SP-23-00010 NH2G – Delvo KVFR Comment Explanation

Fire Marshal comments
Case Number: SP-23-00010

TO: All Staff
FROM: Public Works Plan Review Team
DATE: December 1, 2023, at 5pm
SUBJECT: SP-23-00010 NH2G

SUBJECT: WDFW COMMENTS ON SP-23-00010 NH2G

SHEET 1 OF 3

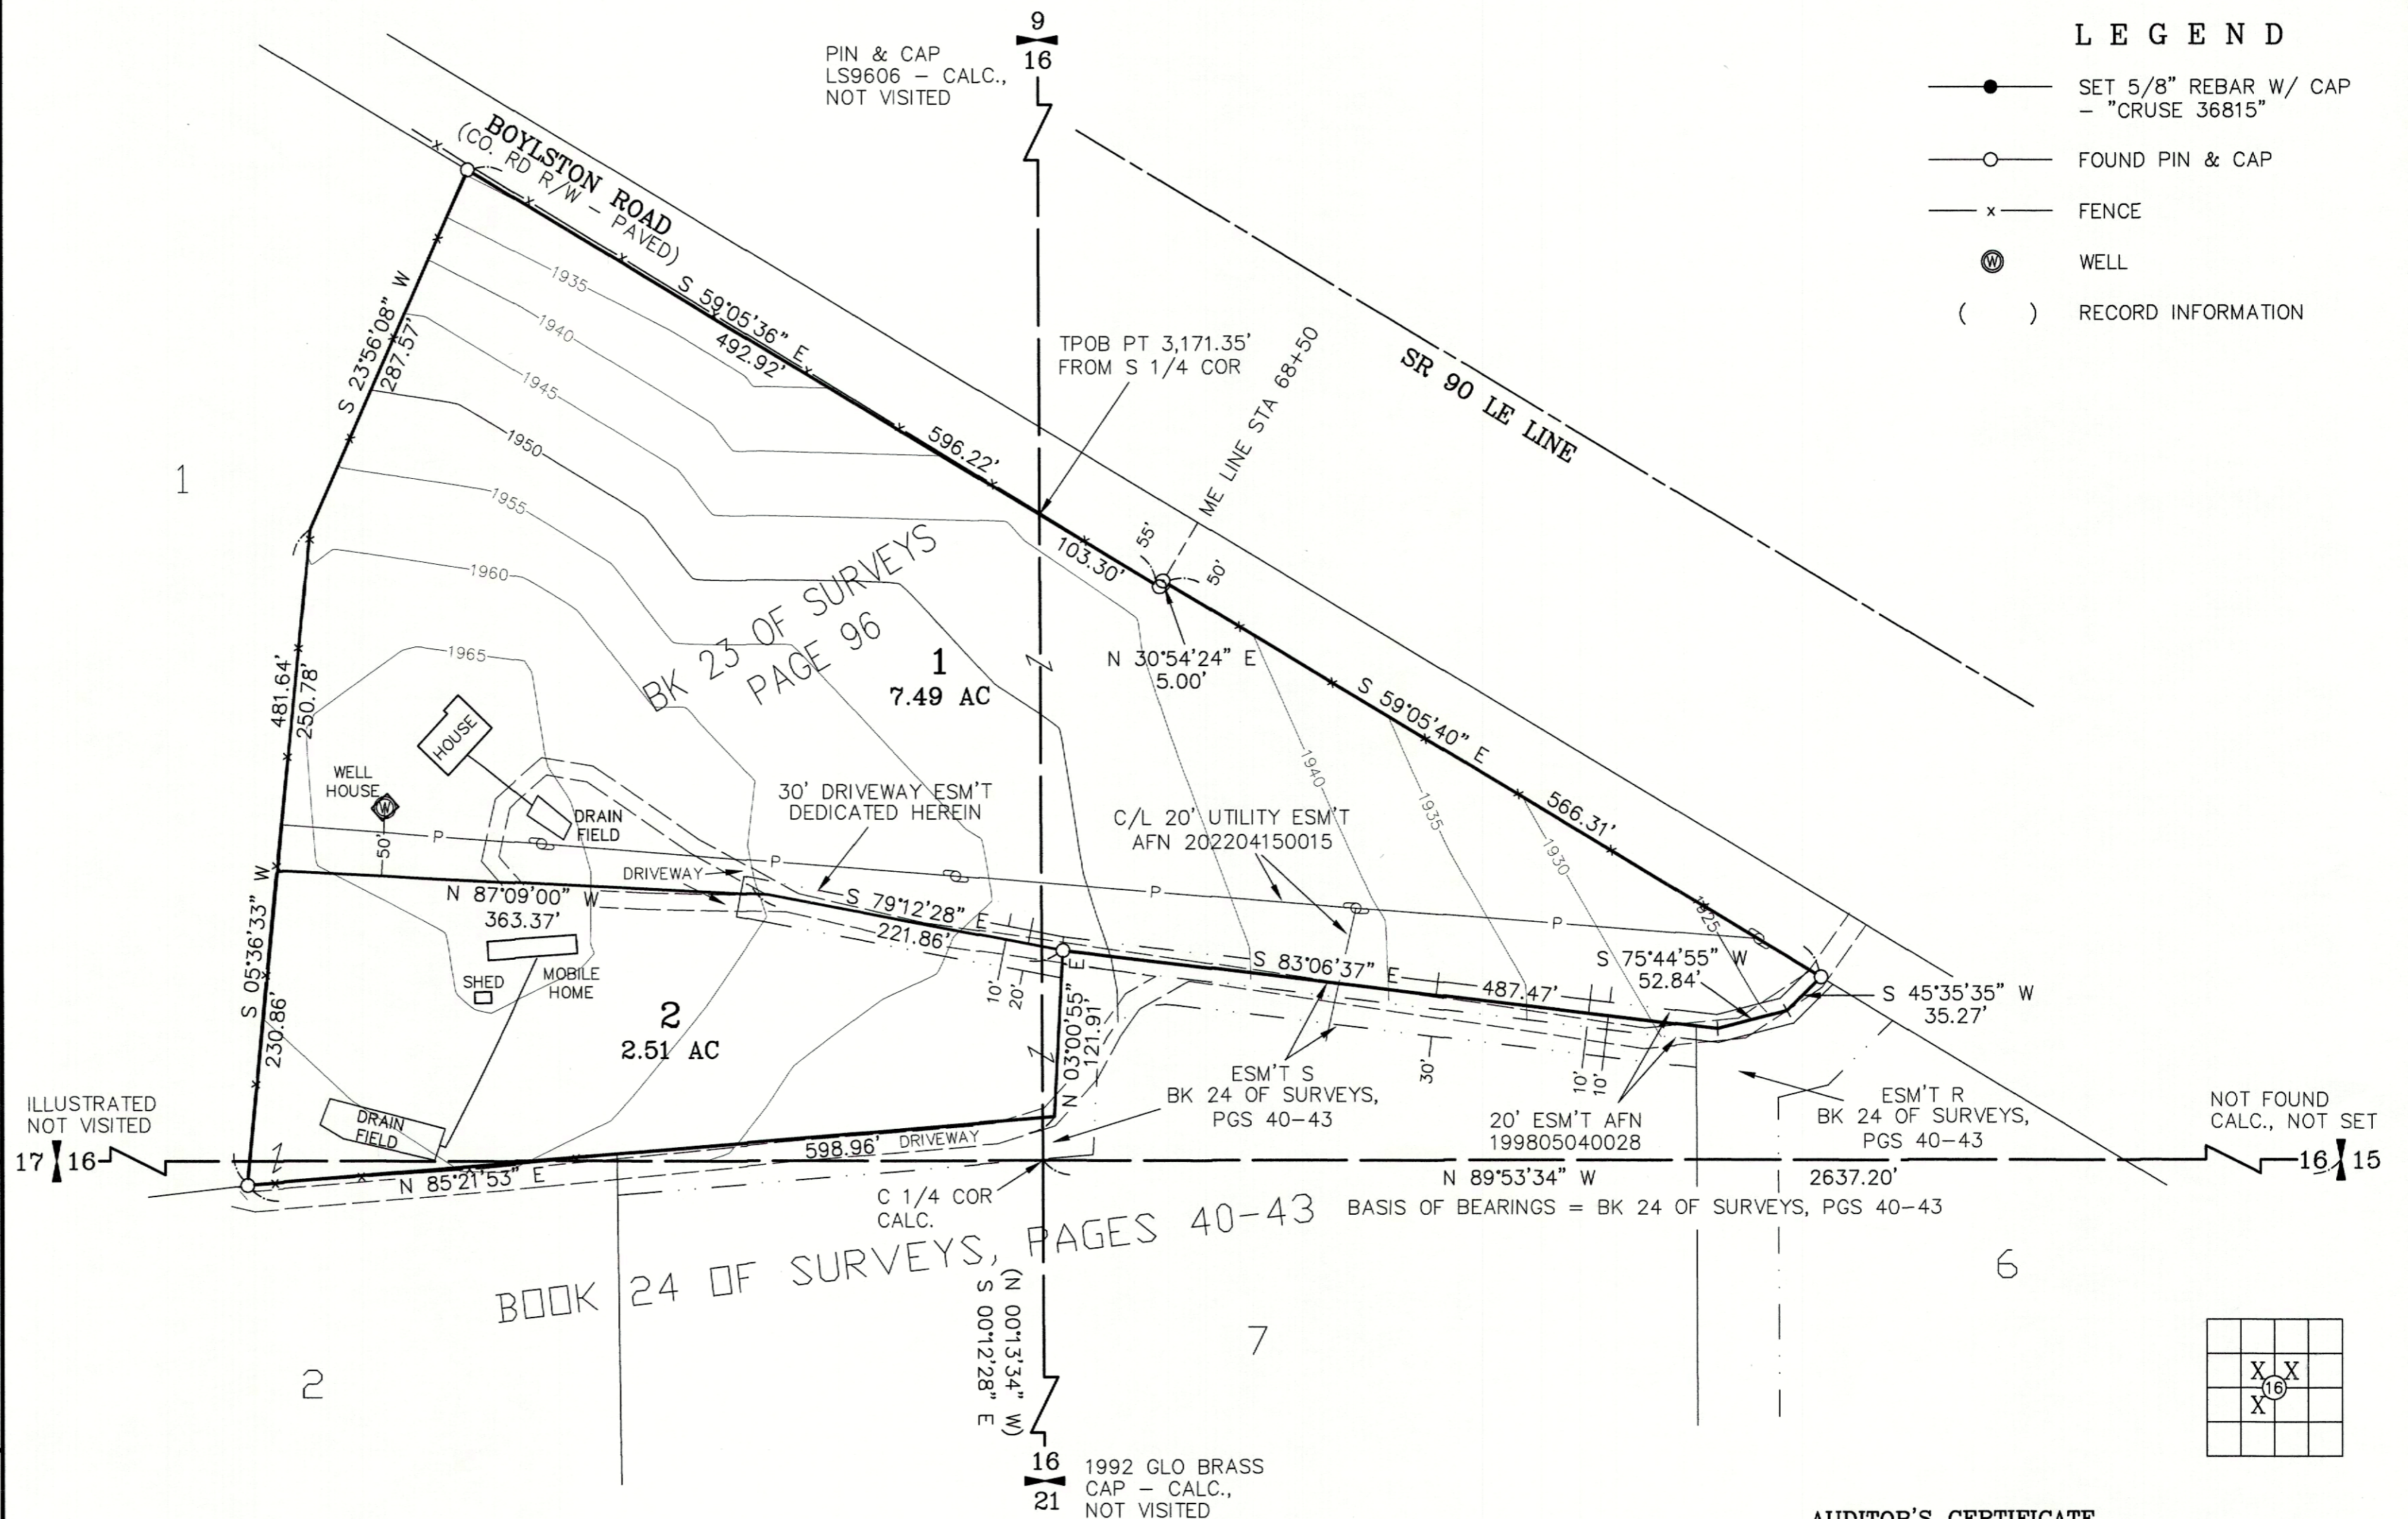
According to Jamey Ayling, Planning Manager of Kittitas County Community Development Services, the applicant will need to build a turnaround & have it be an easement for potential use by Fire and Rescue. The applicant will need an approved fire apparatus turnaround that meets Appendix D of the fire code (2018 IFC).

Approved fire apparatus turnarounds are required for this project. The indicated provisions for turning around fire apparatus are not adequate. Provide a turnaround meeting the requirements of the International Fire Code Appendix D.
